Appeal Decision

Appeal Ref: 6004136

40 Vernon Drive, Harefield, Hillingdon, UB9 6EG

3. The main issue is the effect of the proposal on the living conditions of future occupiers, with particular regard to internal living space.

| Title | Proposed Floor Plans and Roof Plan | | |

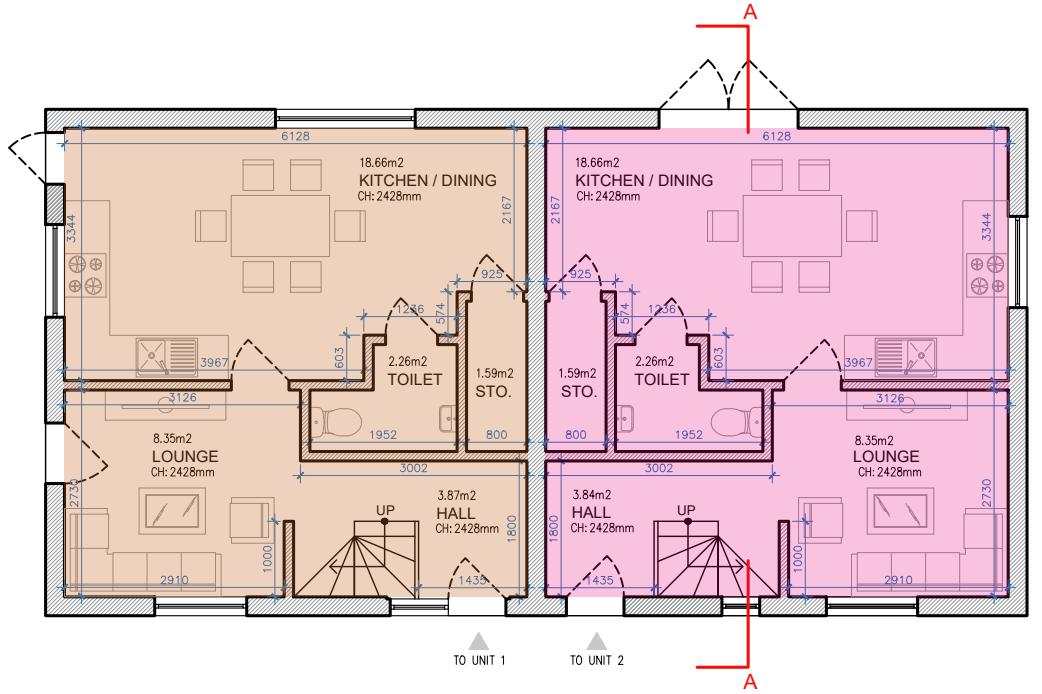
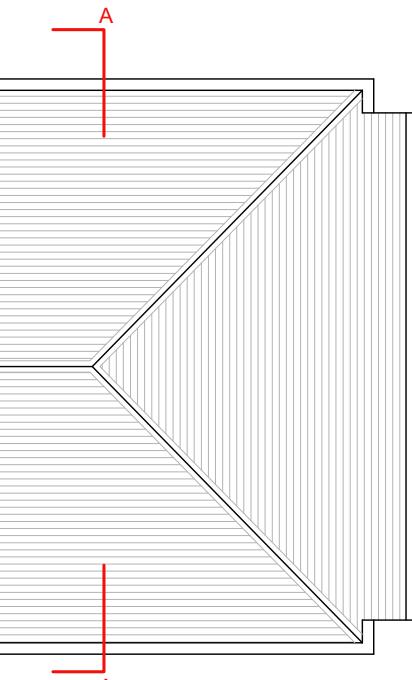
9. There is no dispute between the main parties regarding the gross internal area (GIA) of the proposed dwellings; with each dwelling having a GIA of 75.80sqm. The proposed gross internal floor space of the dwellings would therefore fall considerably short of the 84sqm required by Policy D6 of the London Plan and Policy DMHB 16 of the HLP and would be in conflict with those policies.

11. The proposed ground floor layout would essentially be the same for each dwelling. The proposal makes provision for a kitchen / dining area annotated to be 18.66sqm and a confined lounge of 8.35sqm. A storage area of 1.59sqm falls short of the 2.5sqm storage area set out in Table 5.1 of the HLP and 3.1 of the LP. A hallway and toilet would also be provided on the ground floor.

12. The minimum floorspace standards set out in LP Policy D6 take into account commonly required furniture and spaces needed for different activities and moving around (paragraph 3.6.1). The proposed dwellings each fall short of the internal floorspace standards set out in the development plan by about 8.2sqm. The amount of internal living space relative to the potential number of occupants is therefore substandard and given the substantial shortfall, would be likely to lead to cramped living conditions, insufficient circulation space and inadequate internal space overall to provide a flexible, comfortable and appropriate living environment.
